From: Andrew Wood <Andrew.Wood@arun.gov.uk>
Sent: 21 November 2019 09:29
To: Planning.Responses <Planning.Responses@arun.gov.uk>
Subject: FW: WA/7/19/RES - Lanes End, West Walberton Lane - Additional information request

From: Mark Warwick <Mark.Warwick@arun.gov.uk>
Sent: 23 October 2019 13:02
To: Andrew Wood <Andrew.Wood@arun.gov.uk>
Subject: RE: WA/7/19/RES - Lanes End, West Walberton Lane - Additional information request

WA/7/19/RES - Lanes End, West Walberton Lane - Additional information request

PLOTS 4 AND 5
FLOOR PLANS AND
ELEVATIONS

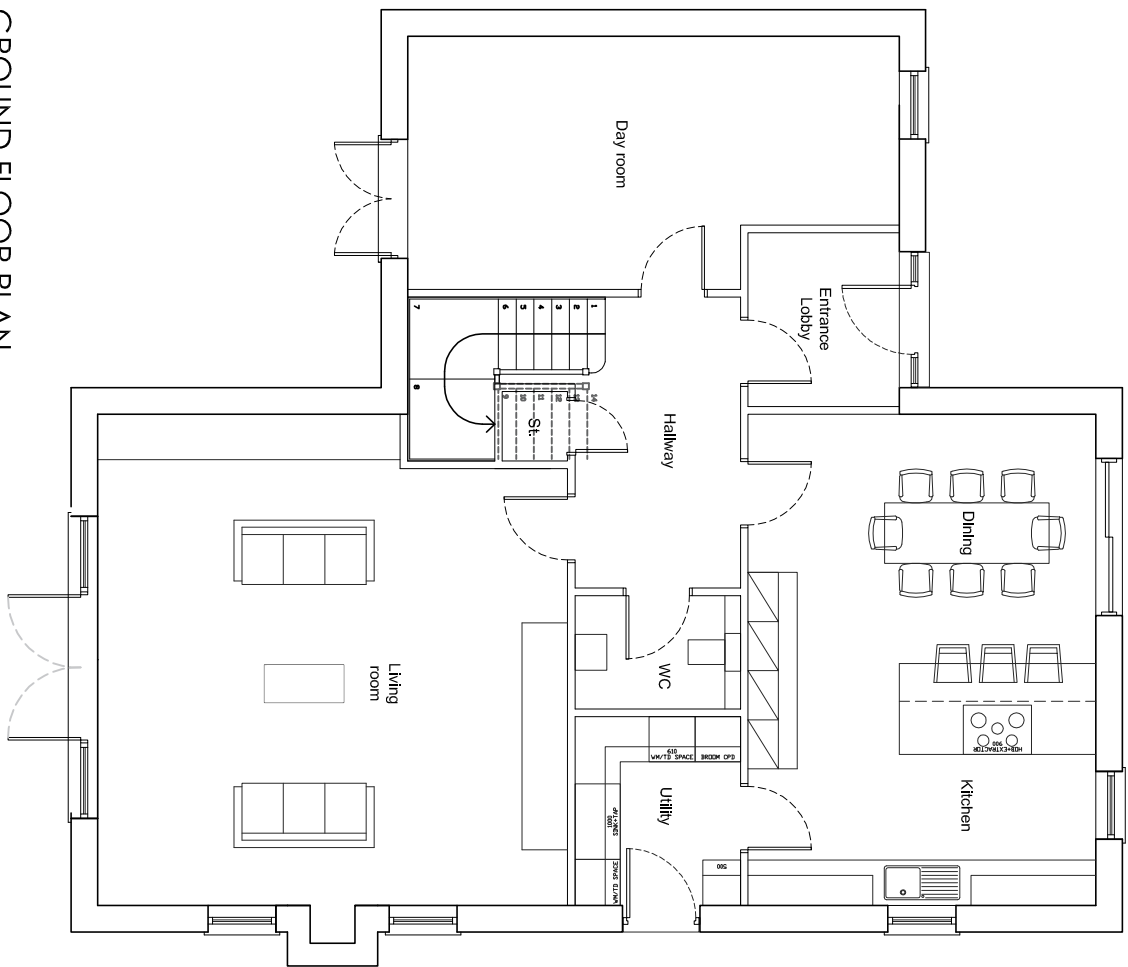
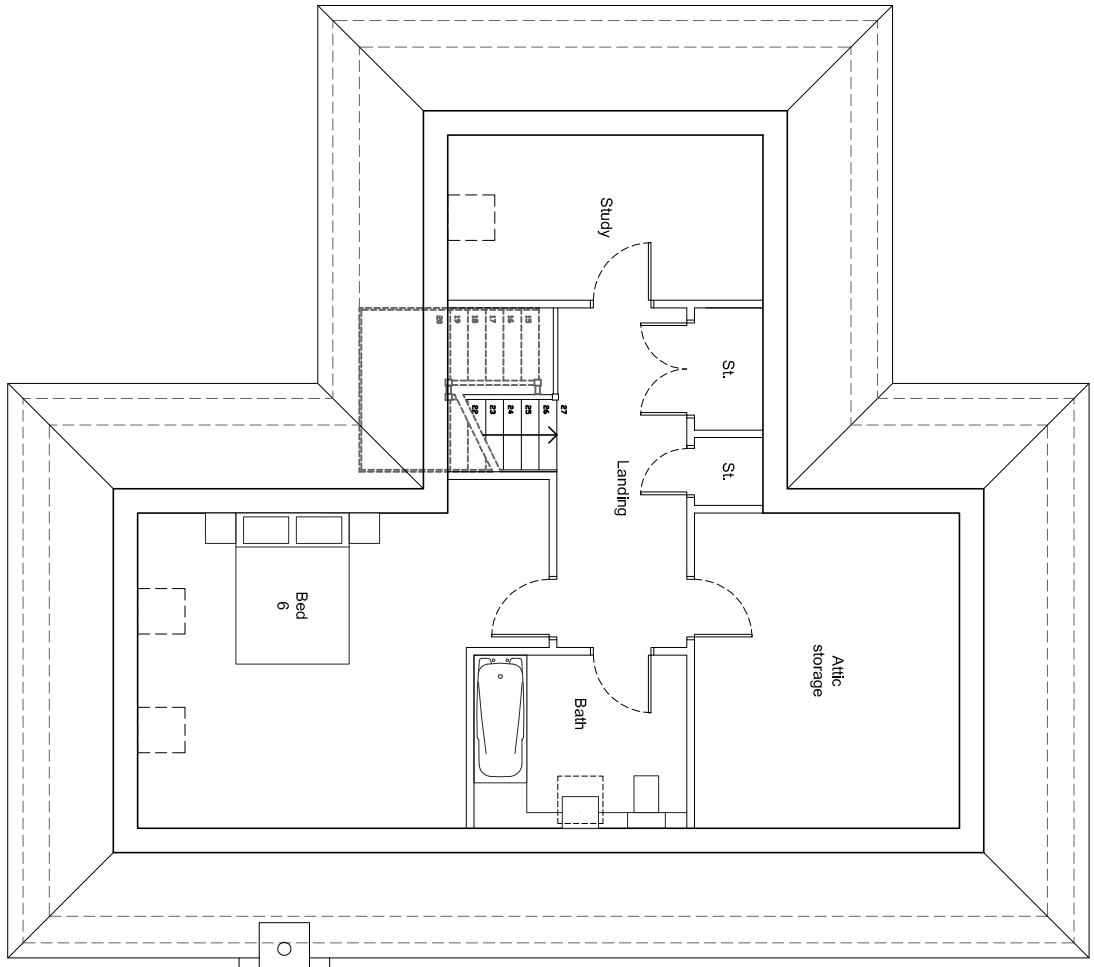
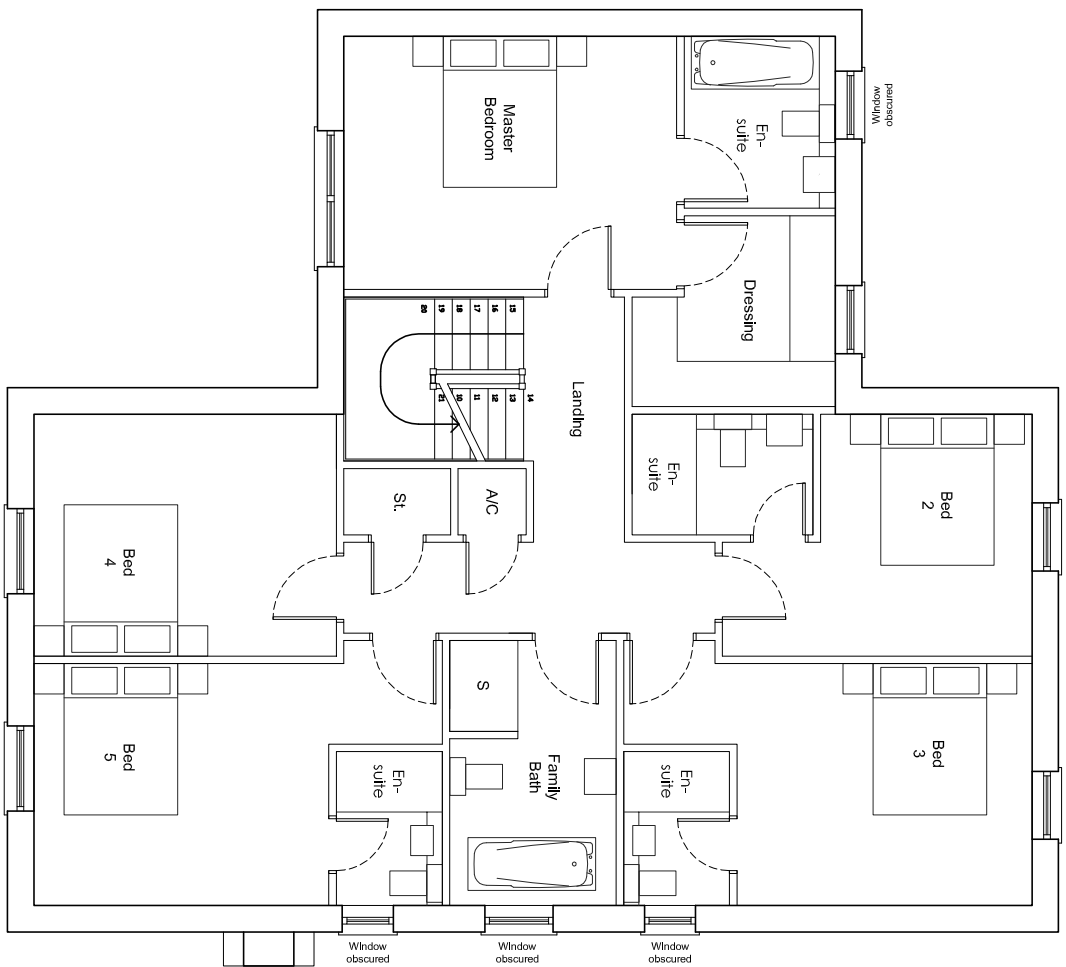
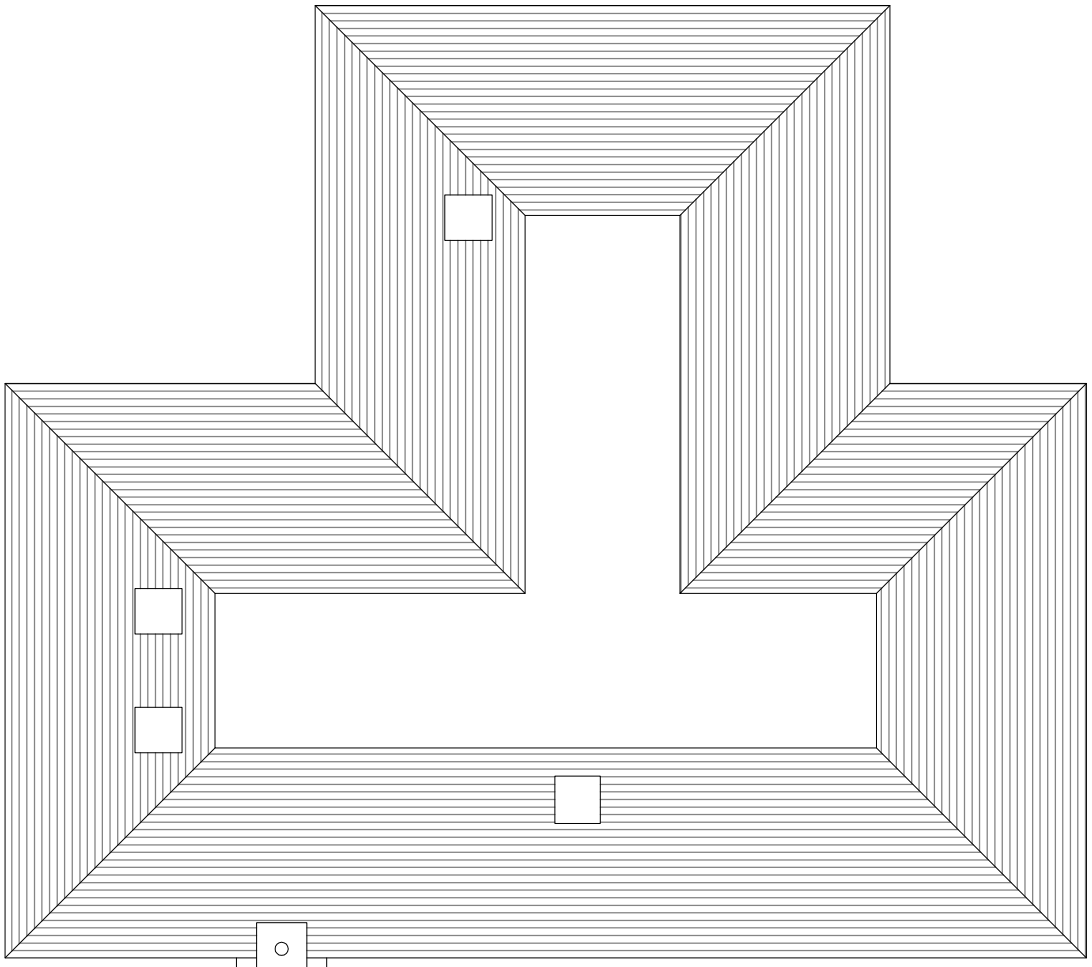
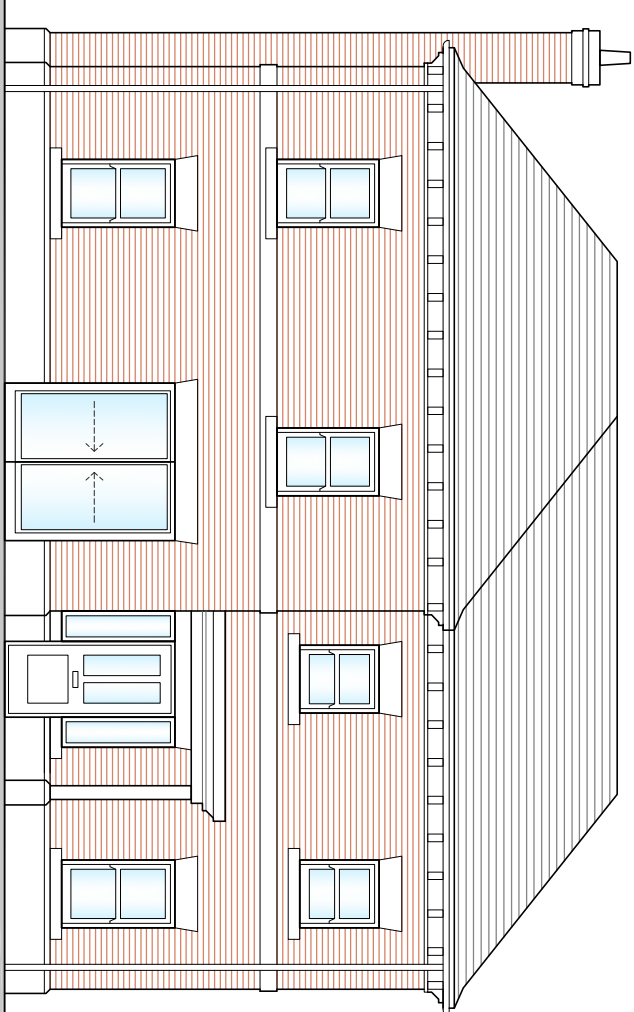
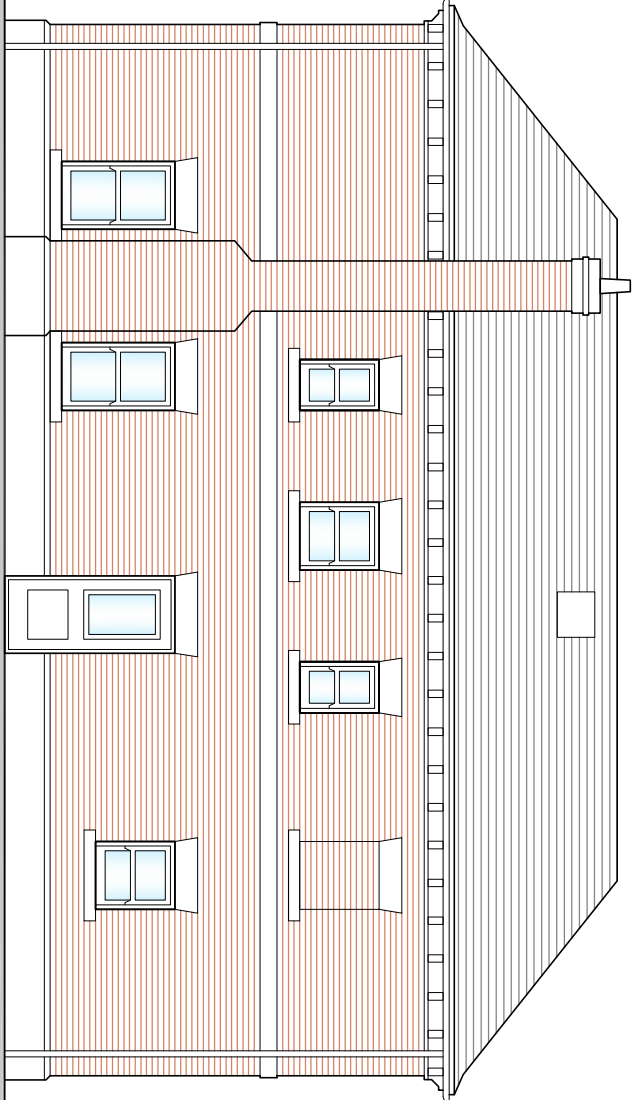
the issue with the rooms in the roof is that the appearance of the dwellings will be of a town house which is simply not appropriate in this location. I would strongly advise you to remove this element from the scheme. To avoid the risk of the development being viewed as 'out of character' in the area and contrary to policy D DM1 of the Arun Local Plan. I have discussed the matter with my line management team and everyone is of the same view in this case.

1. Amend the layout to ensure that a minimum of 9 metres exists on from blank gable end (or obscure glazed windows non opening below 1.7 metres in height) of nearest proposed house to gable end of 'Woodlands' which currently incorporates sole habitable room windows.
2. Remove second storey of houses/rooms in roof. 3 storey townhouses would not be acceptable in this location

2, we fail to see the merit in removing the room in the roof, this would have no impact on the height of the buildings and would result in empty lift spaces which would not allow for good use of space as per the NPPF. You will note from drawing 19-001-PL-03 all the dormers on houses 3-6 are in the south and therefore can not be seen from the front or any point outside the properties. Currently prosperities one and two have the dormers on the north but I would be happy to move these to the south so these are the same and none can be seen from Arundel road. I also would like to mention the design of white cottage next door that will have dormers in the roof and Richmond house which has velum windows in the roof. As previously mentioned the new ridge heights will be lower than the current house at Lanes end this can be seen in the scale drawings provided. If you could let me know if this is acceptable as if possible to avoid I would prefer not to have to appeal the reserved matters for this small item.
